Our Ref: BR/155/19/PL
Your Ref:

Town & Country Planning Act 1990 (as amended)
Town and Country Planning (Development Management Procedure) (England) Order 2015
Application for Planning Permission

Development Replacing rotten wooden windows with PVCu double glazed windows. This application affects the character & appearance of the Upper Bognor Road & Mead Lane Conservation Area & may affect the setting of a listed building.

Location The Mews 1 - 6 Mead Lane Bognor Regis

The Mews, Mead Lane, Bognor Regis, PO22 8AL

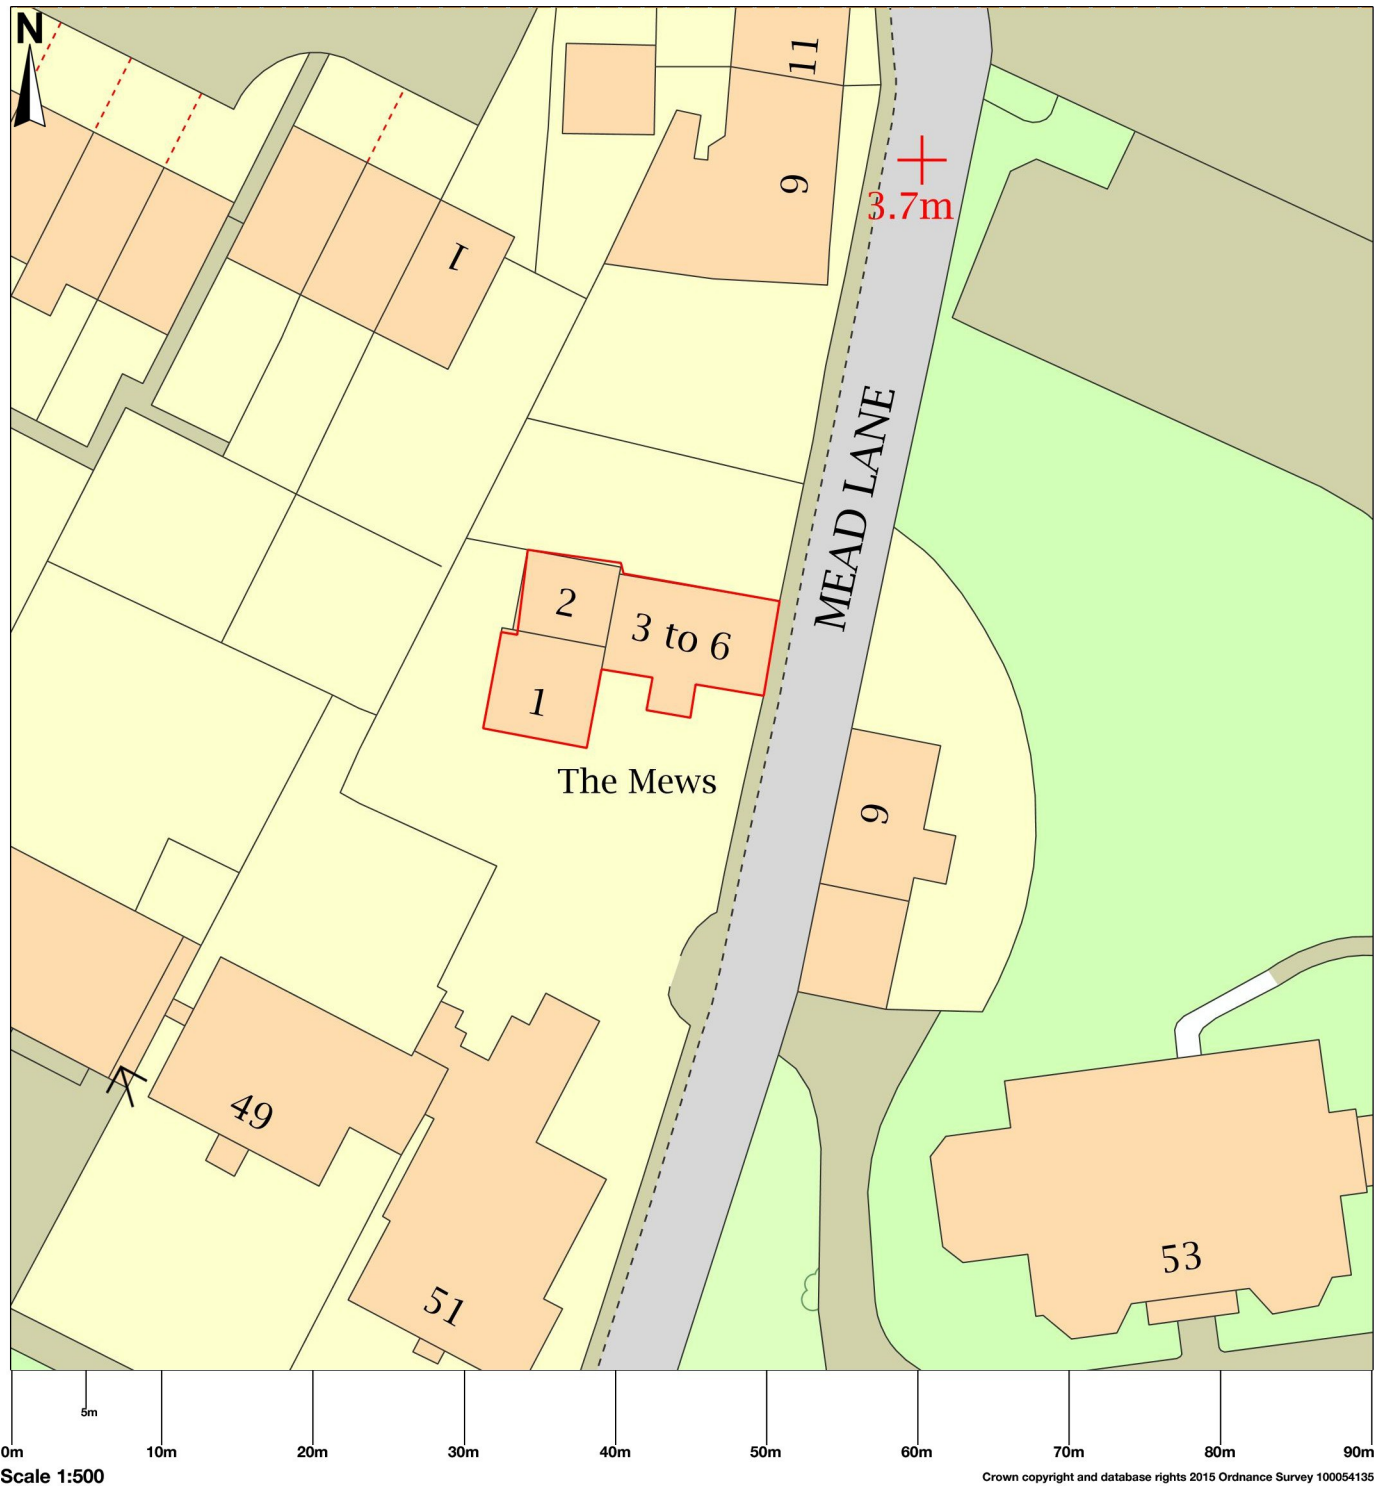
Block Plan Amend

Please show the position of all windows being replaced.

Please provide which flat(s) are having windows replaced (Flat 1, Flat 2 etc).

Please provide the total number of windows being replaced.

Please indicate if the windows are on both side elevations or only one.
